Attachment M – Detailed Response to Submissions Table

Attachment M – The Children’s Hospital at Westmead – Paediatric Services Building (SSD- 10349252) – Detailed Response to Submissions Table

PRIMARY TANK LOCATED AT LOWER LEVEL

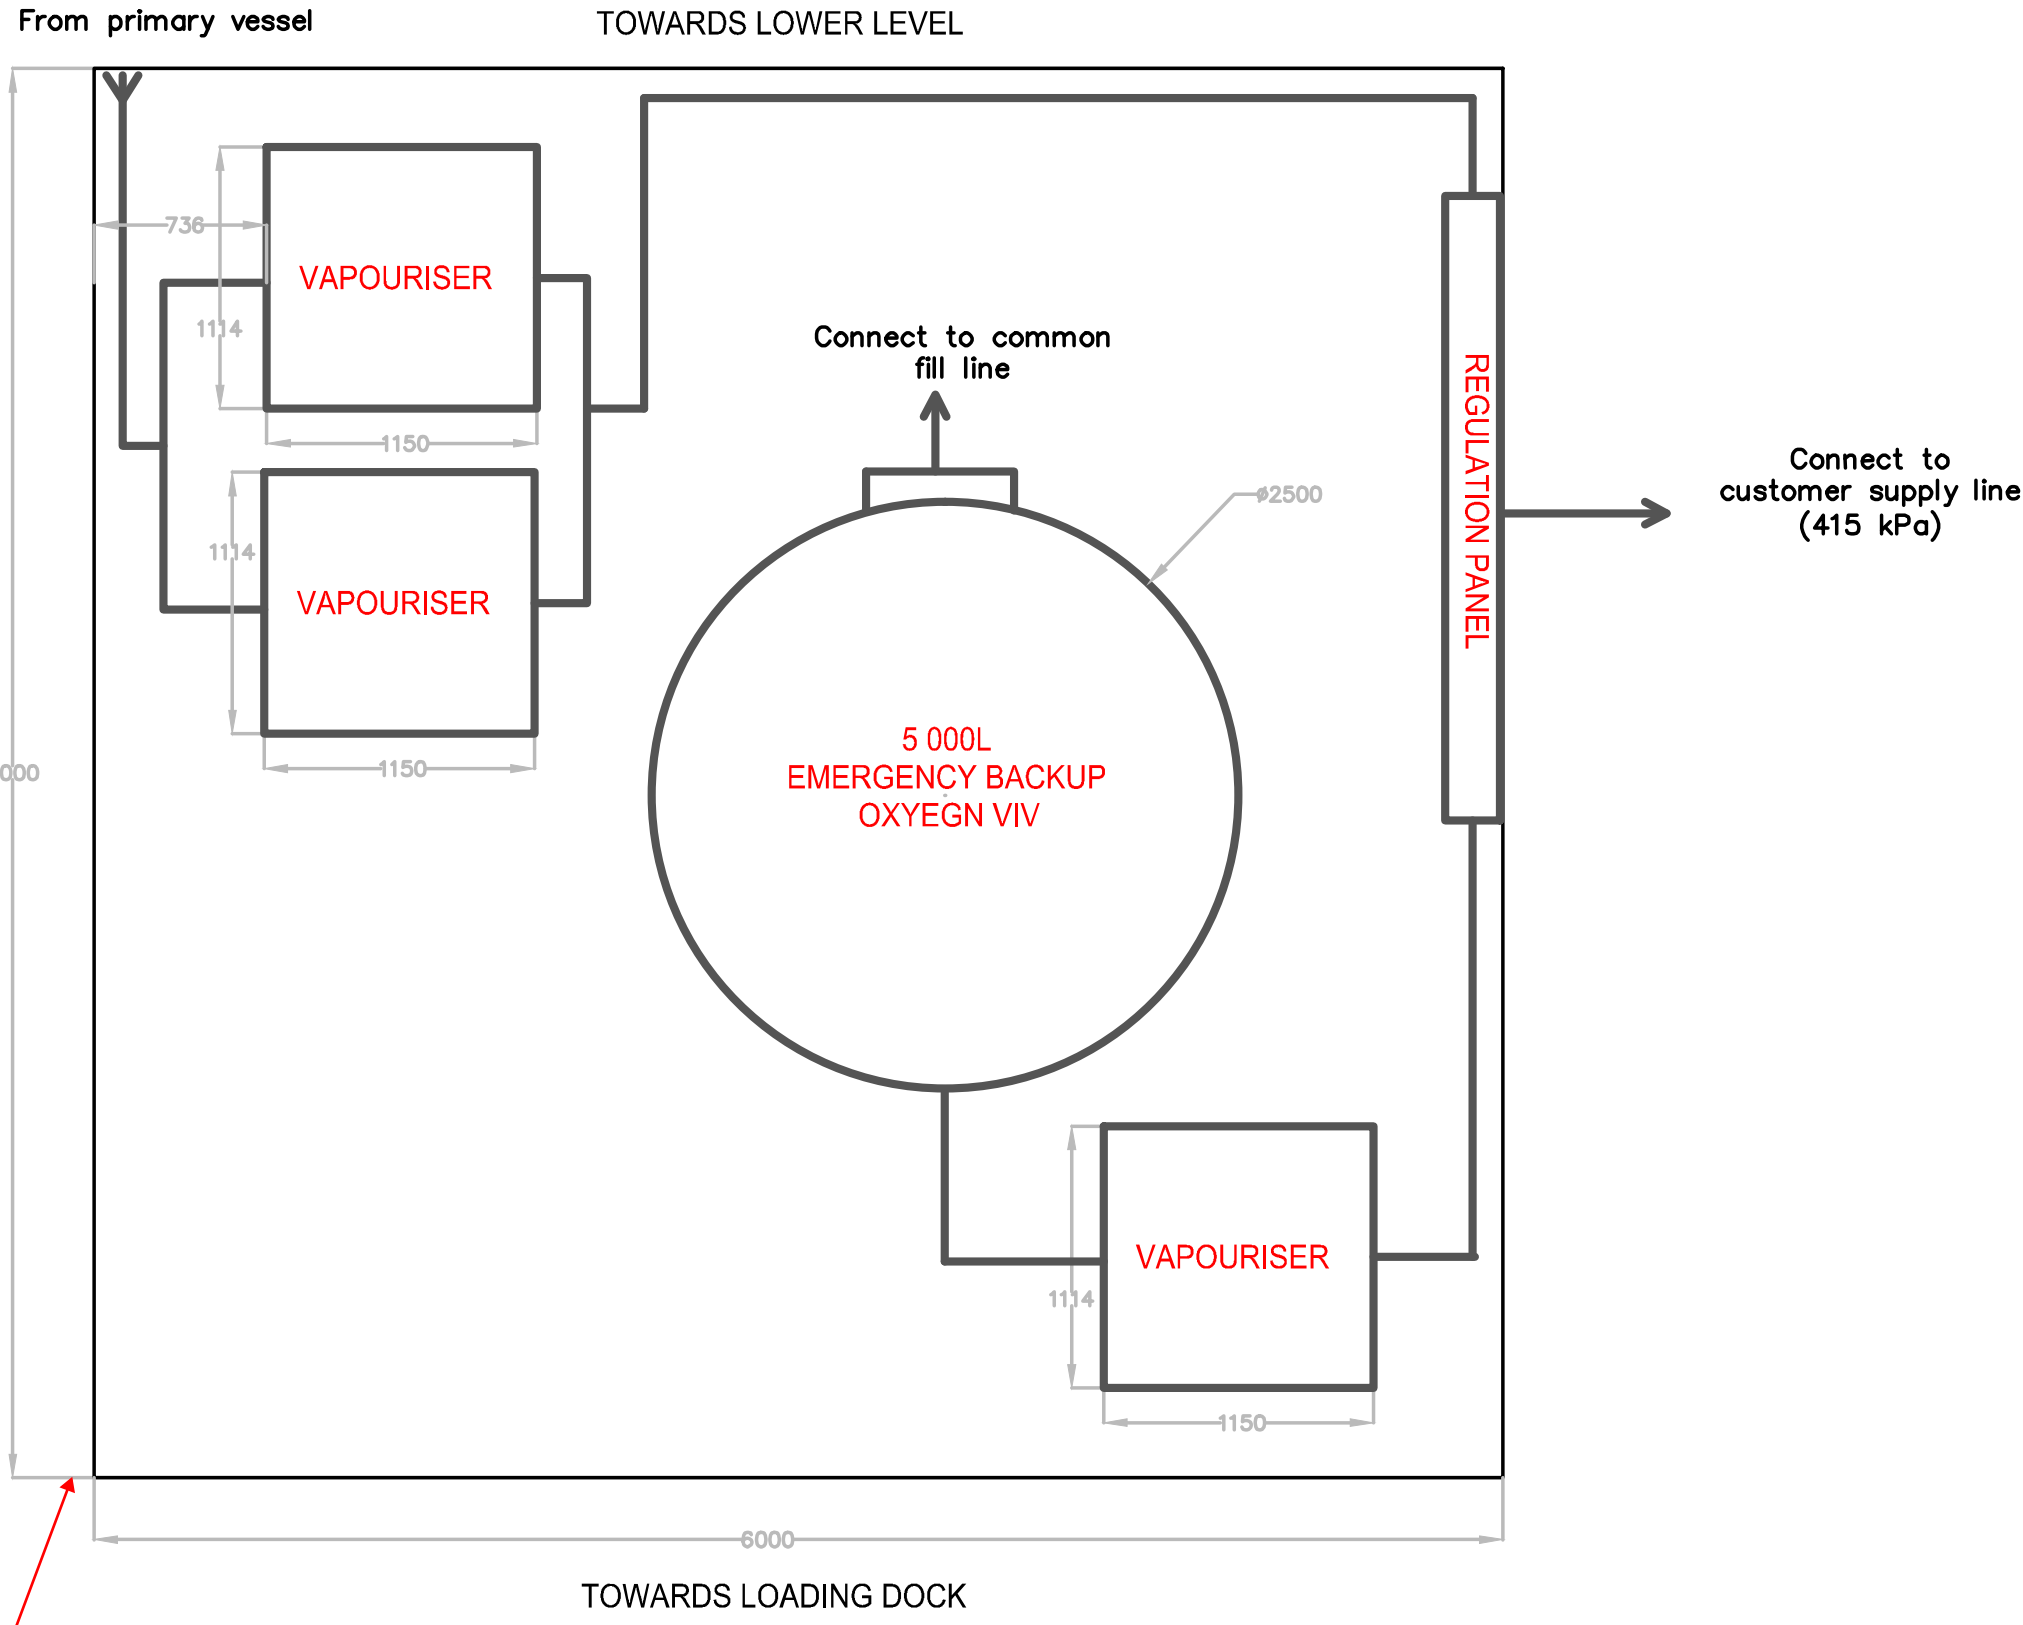
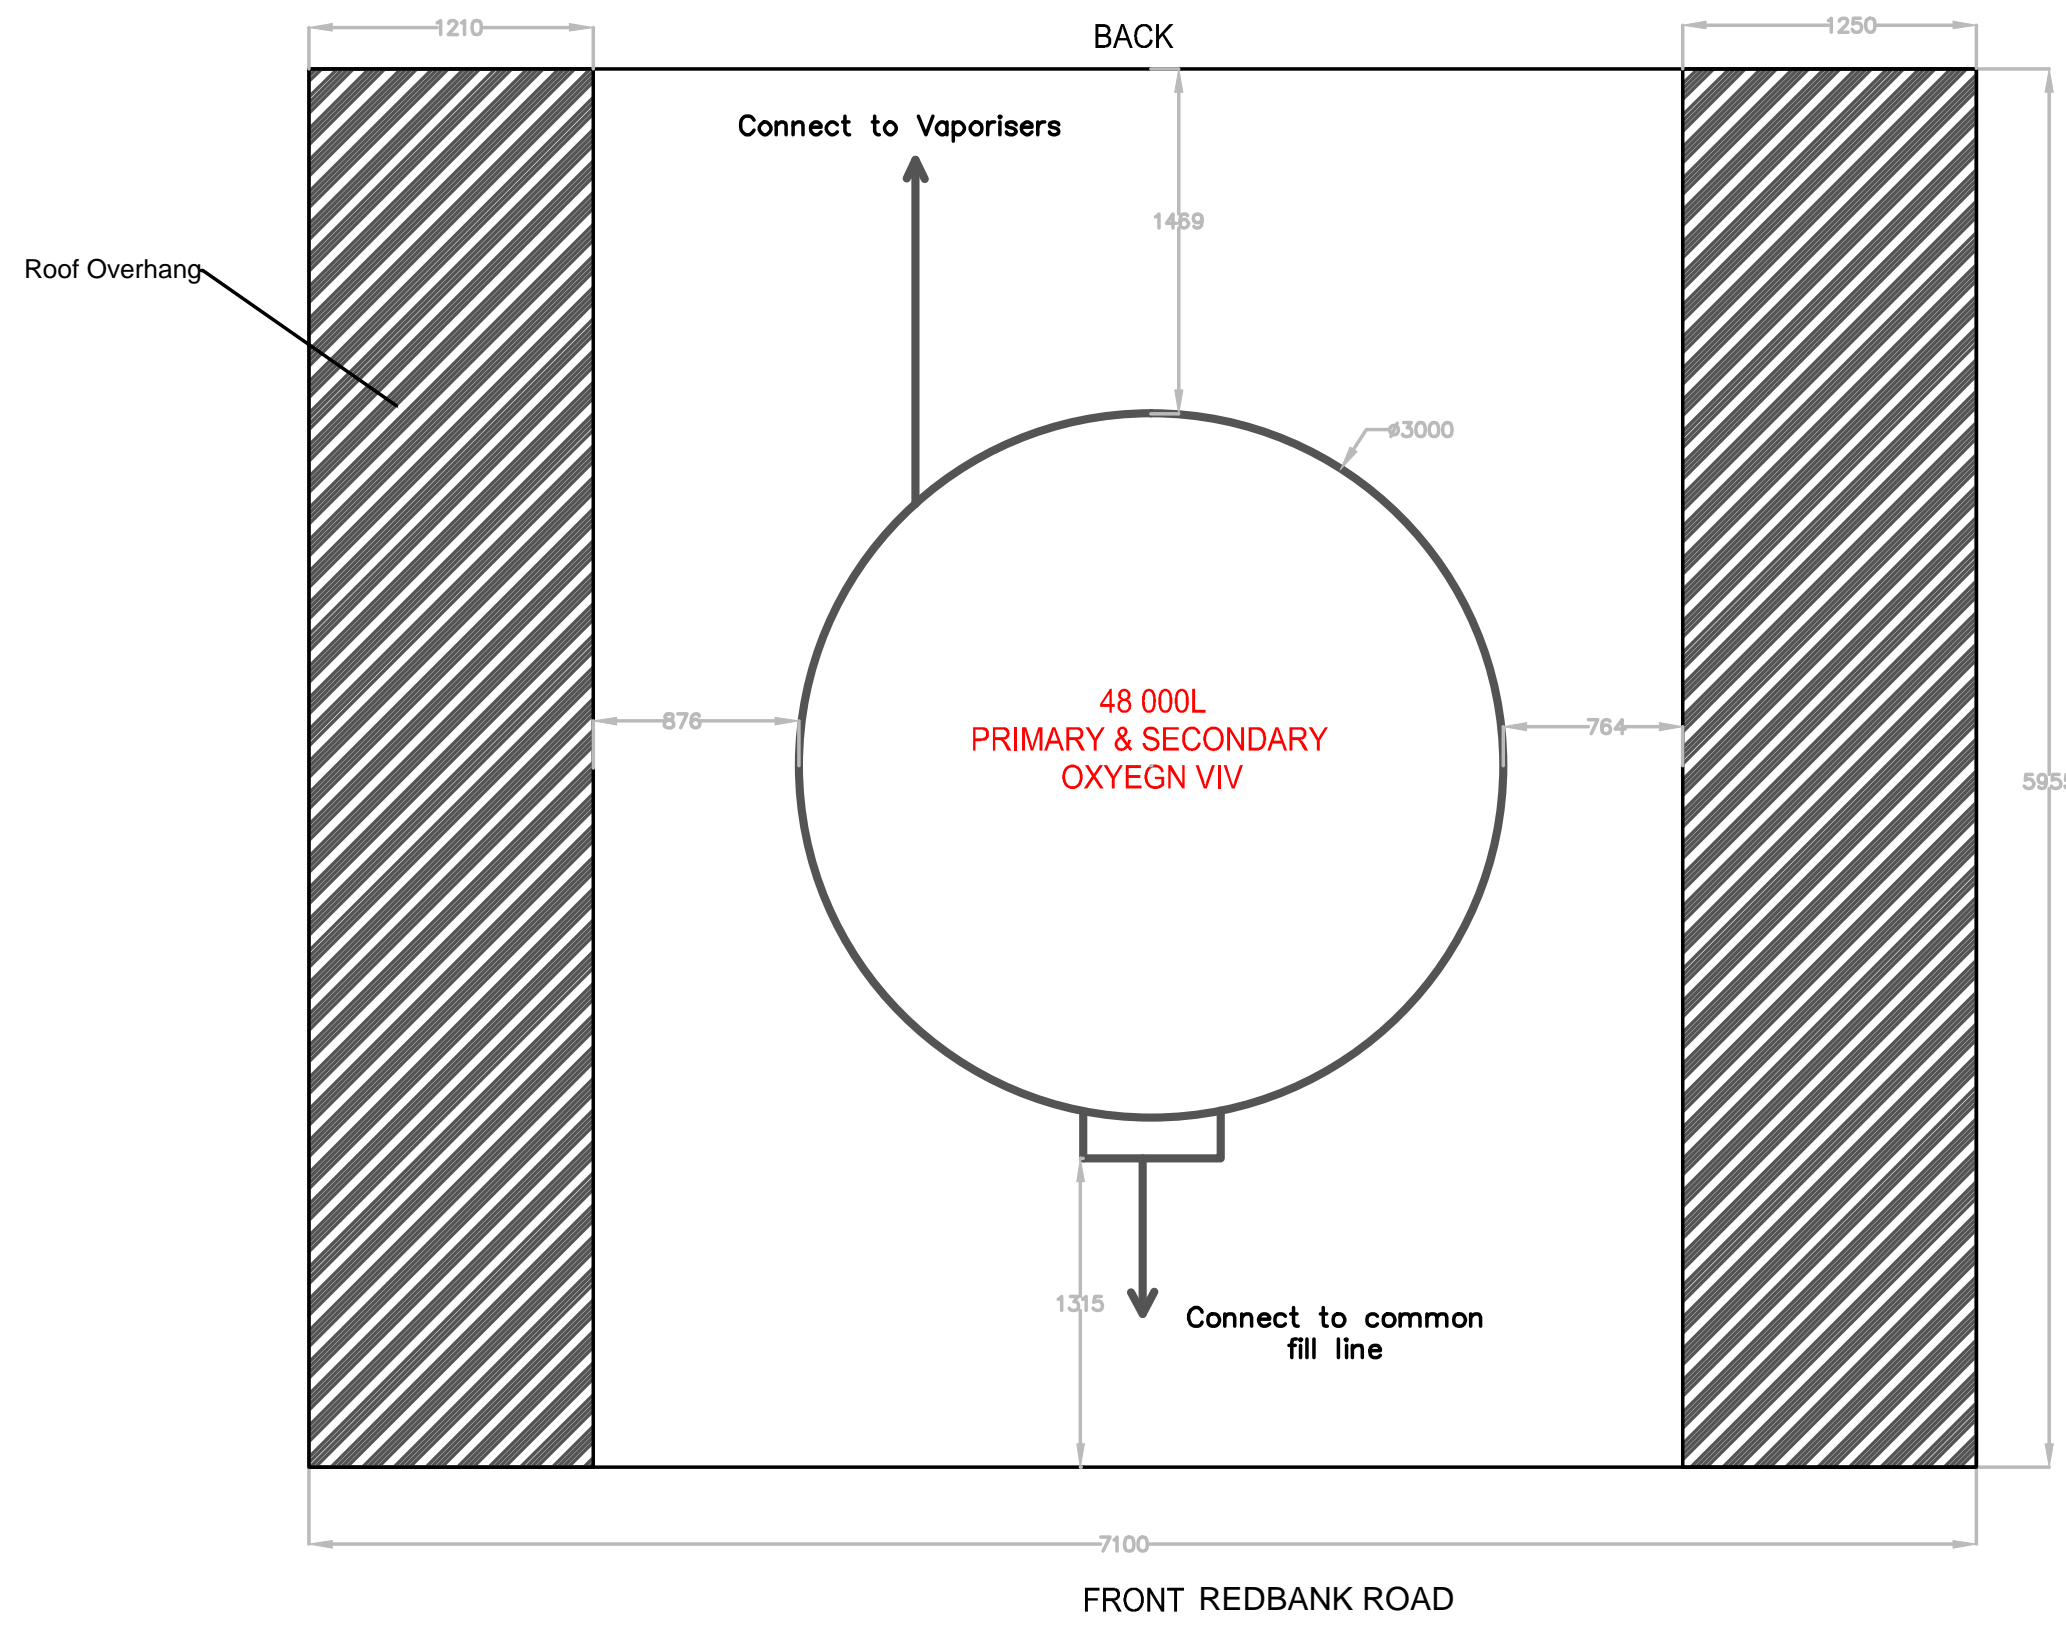
Comment in submission	Applicant's response
		<p>The primary oxygen tank will be located on the lower-level platform of the existing CHW loading dock, while the back-up tank will be located on the upper-level platform of the existing CHW loading dock.</p> <p>The transitional arrangement is for the 5,000 L back up vessel to be installed on the upper platform and commissioned to supply the hospital, before the existing vessels are removed, and the main supply tank is replaced. This will ensure the continuous supply of oxygen to the hospital during the installation of the new tanks. A revised Preliminary Hazard Analysis (PHA) has been prepared by Arup at Attachment J, and a Design Memo relating to the Gas compound prepared by Stantec at Attachment K. Both documents provide support and assurance for the revised arrangement.</p>
15	<p>Hazards</p> <p><i>Confirm that the two liquid oxygen tanks are to be located within the loading dock area located to the south of Redbank Road as indicated in drawing CHW-AR-DG-PSB-SSD00 Revision A..</i></p>	<p>It is confirmed that the liquid oxygen tanks will be located in the existing CHW loading dock. Refer to the Design Memo prepared by Stantec at Attachment K.</p>

Figure 15: Classification of wind safety at 1.5 m above local ground level

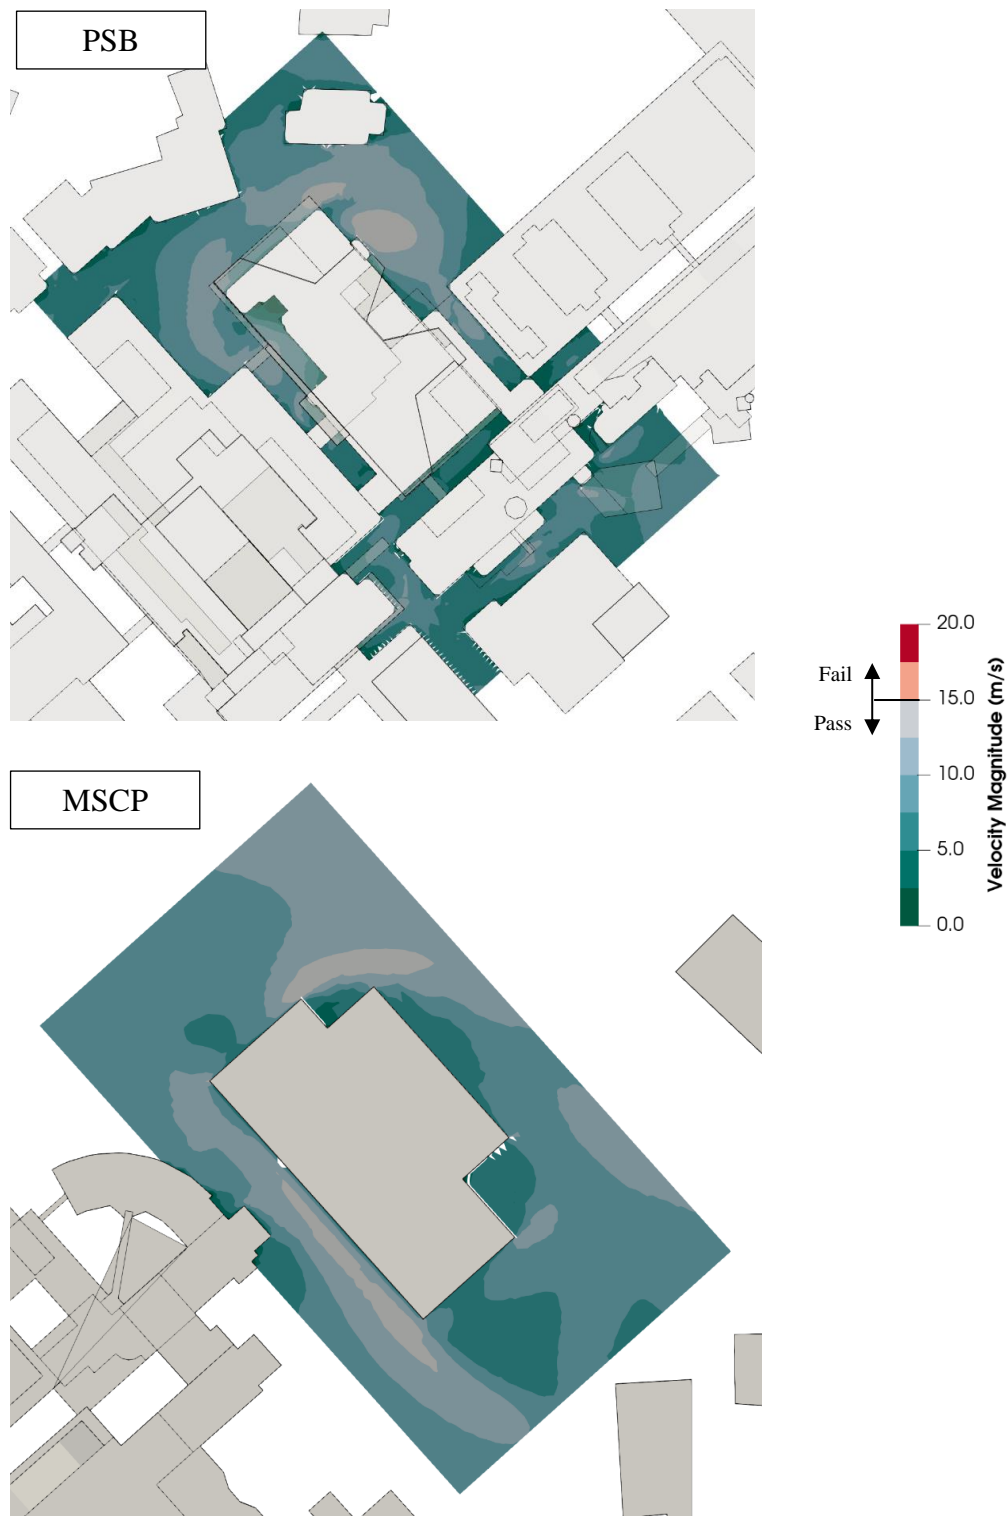
Comment in submission	Applicant's response
		<ul style="list-style-type: none"> – A Contextual Response to Parramatta River and surrounds – Connection to Country through the use of natural colours and textures – A Reflecting Place by Reflecting Nature – materials and colours working harmoniously with the landscape design – Characteristics of the River and the Riverbank – materials, colours, and ephemeral qualities of the river
10	<p>Wind</p> <p><i>Provide further detail of the pedestrian comfort levels for each landscape terrace on the multiple levels of the PSB.</i></p>	<p>The PSB external terraces/courtyards at the following locations have been assessed for pedestrian comfort and safety at:</p> <ul style="list-style-type: none"> – Level 02 KIDSWAY terrace; – Level 06 accessible landscaped terraces (north and south); and – Level 07 courtyards (north and south). <p>From a comfort perspective, all areas of the terraces/courtyards are classified as suitable for walking or better, with the majority of areas classified as standing or sitting. The safety criterion is met for all terraces/courtyards. Refer to Figure 5 and Figure 6.</p>  <p>Figure 5 Classification of wind safety at 1.5m above local ground level – external terraces/courtyards Source: Arup</p>

Comment in submission	Applicant's response
		 <p>Figure 6 Classification of wind comfort at 1.5m above local ground level – external terraces/courtyards Source: Arup</p> <p>For further detail, refer to the revised Environmental Wind Assessment Report prepared by Arup at Attachment F.</p>
11	<p>Transport</p> <p><i>The cumulative construction impacts are to be further investigated and assessed, taking into consideration light rail works and concurrent building construction works.</i></p>	<p>It is expected construction of the PSB may coincide with construction of the Parramatta Light Rail (PLR) and Sydney Metro West.</p> <p>While construction vehicles will have origins and destinations from a wide variety of locations, construction vehicles are generally limited to the arterial road network, and dedicated construction vehicle routes are developed with the aim to provide the shortest distances to/from the arterial road network.</p> <p>The primary construction vehicle routes for the PSB are likely to include to/from north and east via Redbank Road and Briens Road and to/from south and west via Institute Road, Darcy Road and Cumberland Highway. Redbank Road would be the preferred route, as it provides a more direct access between the site and the arterial road network to/from the site from the north-east.</p> <p>These routes are shown below in Figure 7 and Figure 8.</p>
